From: simon collins [REDACTED]
Sent: 12 August 2015 16:47
To: Daniel Vick
Cc: Janice Chapman
Subject: Objection to Application: FP/133/15/HH

FP/133/15/HH
Midway,

Proposed Ground and First Fl

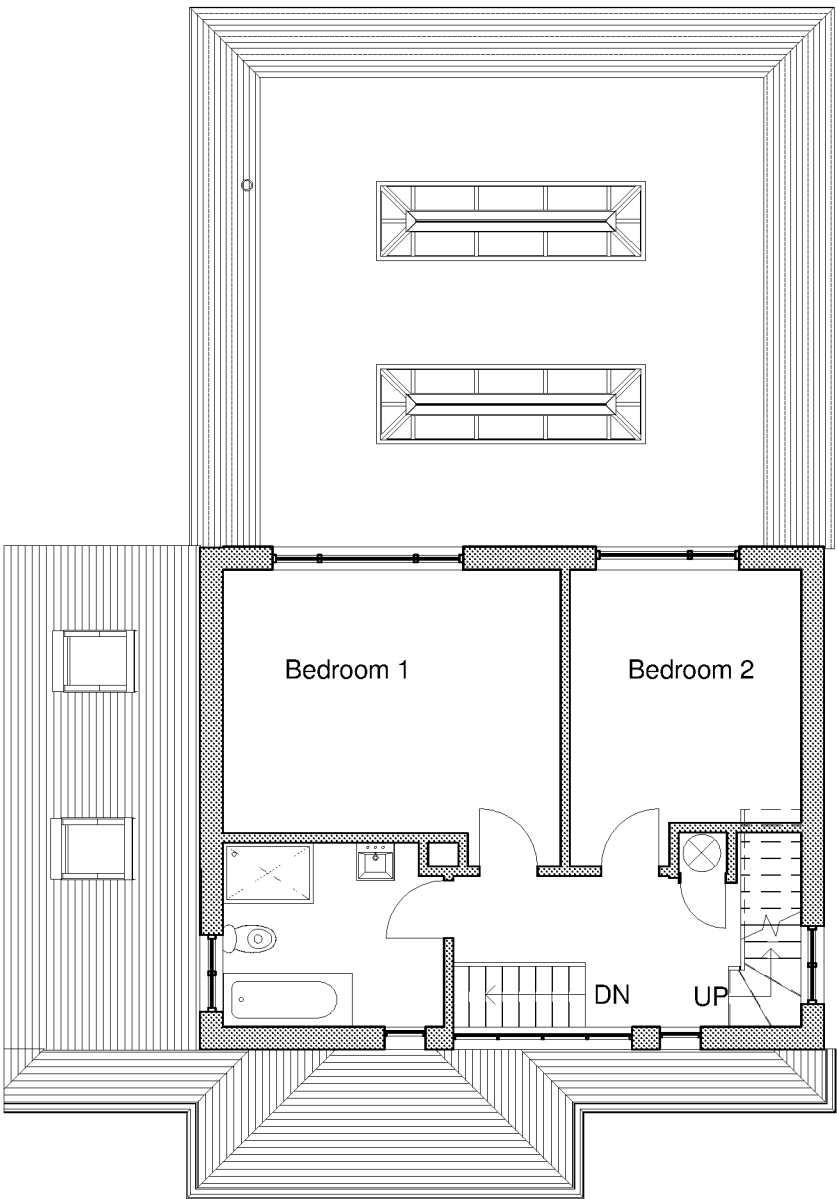
(3) The Design, appearance and layout of **The Proposed Utility Room** (rear). This will bring the end of the rear wall to close with my front door (located in the side alley).

(1) This layout will affect the level of daylight and privacy at my property by being so close to my front door and bathroom window.

The alley way between the two properties is about 3-4 foot wide only. The proposed application would mean upon exiting my front door you'd have a brick wall. Currently there is fence and hedging. The brick wall required for the Proposed Utility room is higher than the current fence and hedge therefore reduces our daylight

This will mean a loss of privacy to us because our front door and bathroom window will be alongside, overlooked and too close to their Proposed Utility Room.
